## Meeting note

<b>Project</b>	AQUIND Interconnector
<b>File reference</b>	EN020022
<b>Status</b>	<b>FINAL</b>
<b>Author</b>	The Planning Inspectorate
<b>Date</b>	28 August 2019
<b>Meeting with</b>	Aquind
<b>Venue</b>	Telecon
<b>Meeting objectives</b>	Project update meeting and review of draft documents
<b>Circulation</b>	All attendees

### Section 51 Advice – draft Application Document by AQUIND Limited for PINS review

**AQUIND Interconnector
Hedgerow and Tree Preservation Order Plans
KEY PLAN**

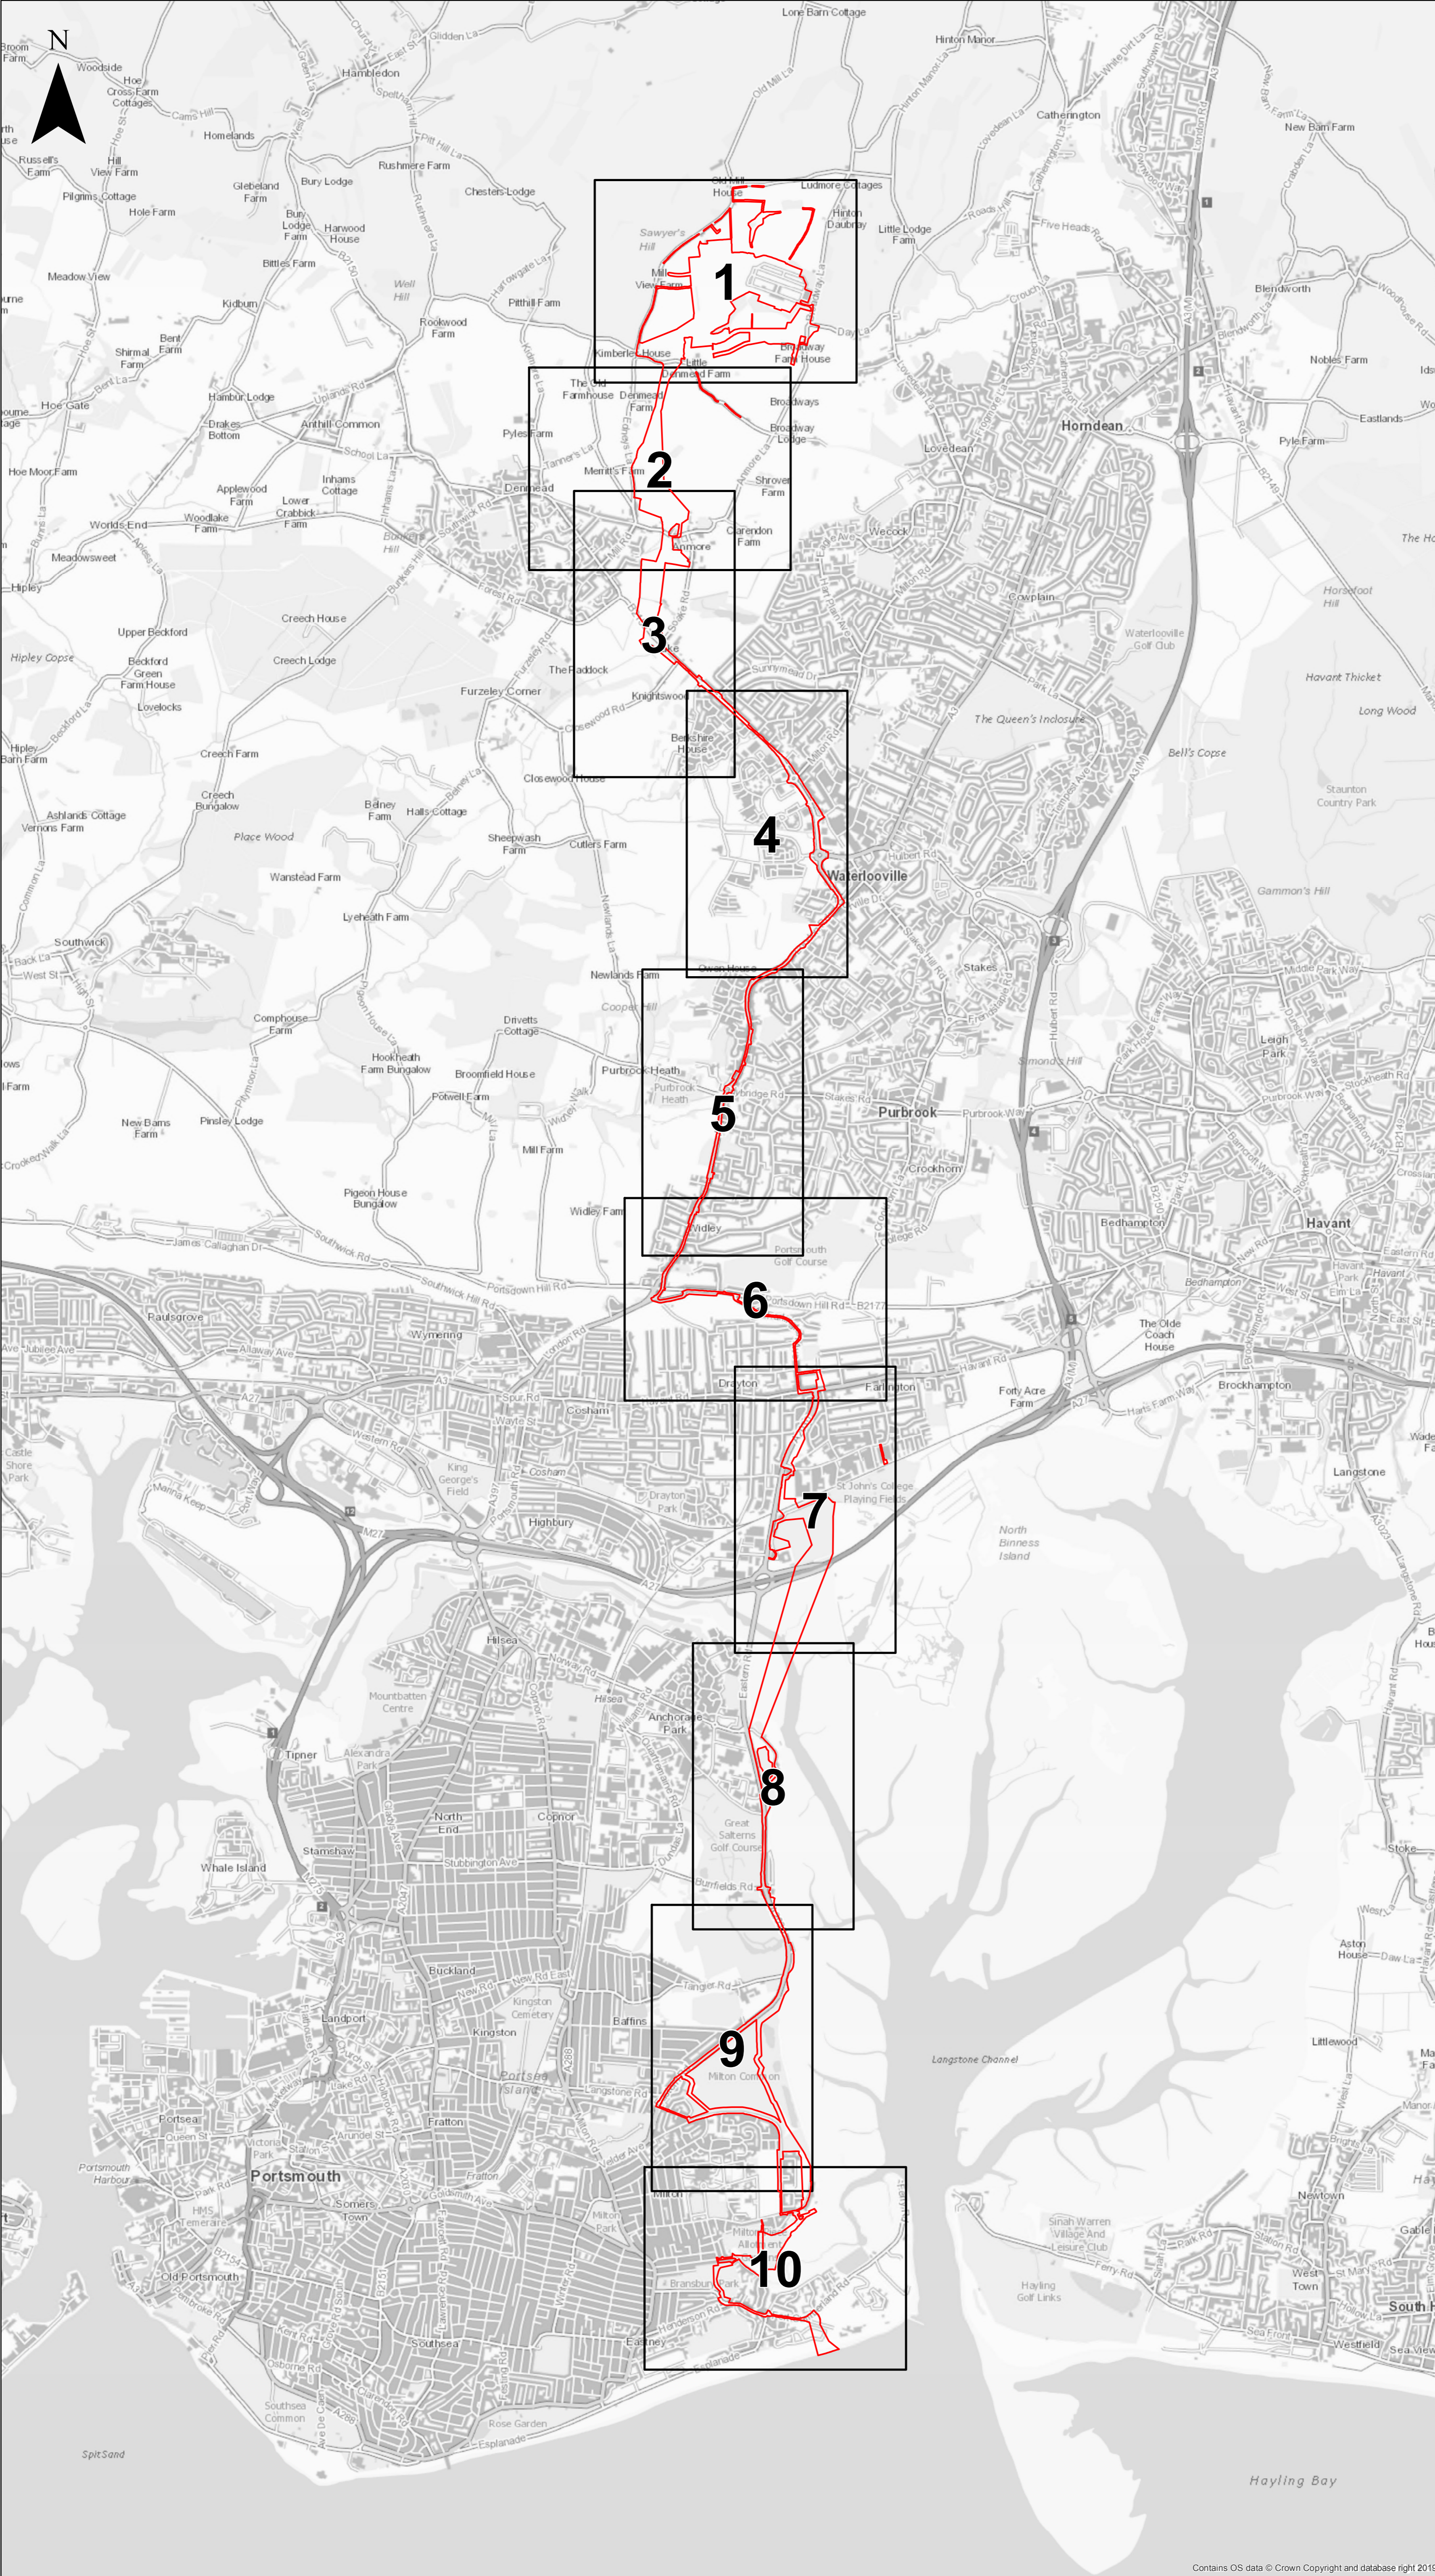
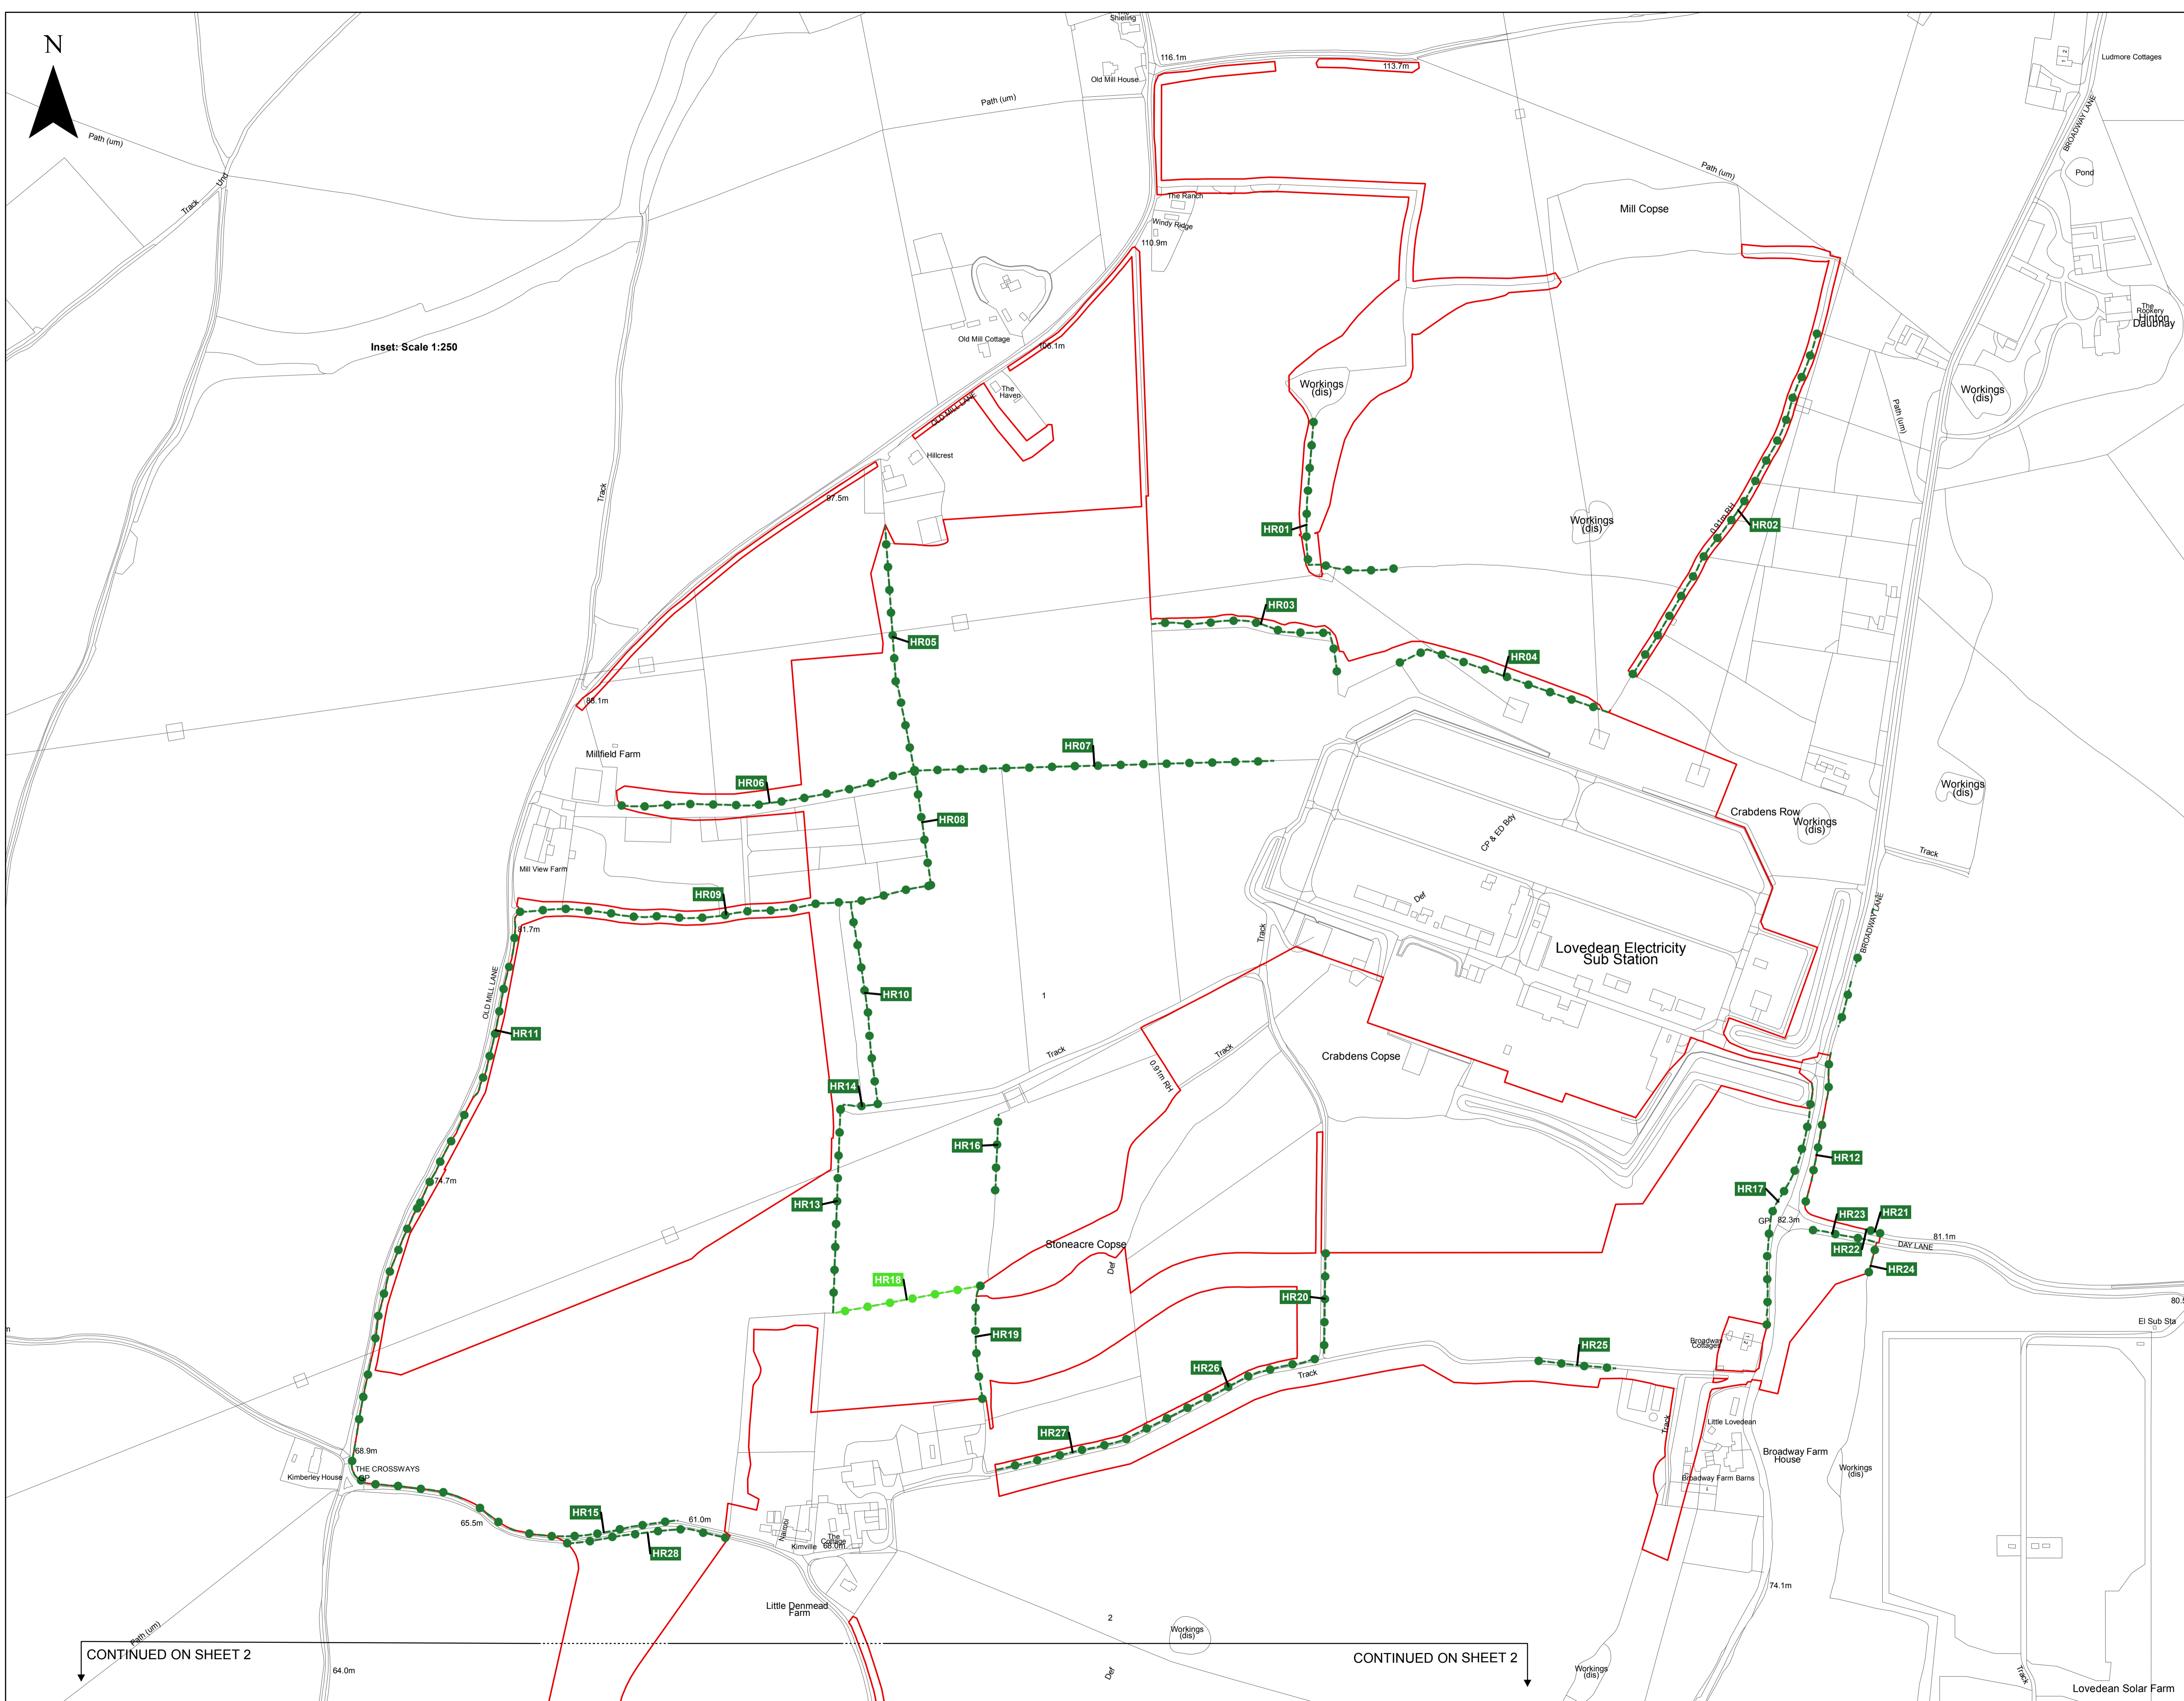
12.	Article 40(4)(a)	Felling or lopping of trees [and removal of hedgerows]	Please refer to AN15 where it states that 'Hedgerows affected by the Proposed Development should be identified in a Schedule to and on a plan accompanying the draft DCO. The Schedule and plan could also helpfully identify those hedgerows that are 'important' hedgerows.

Draft Development Consent Order			
Q No.	Article (A)/ Requirement (R)	Extract from DCO (for ease of reference)	Comment/Question
			Therefore it is advised that all hedgerows are identified in a schedule, and not just important hedgerows.
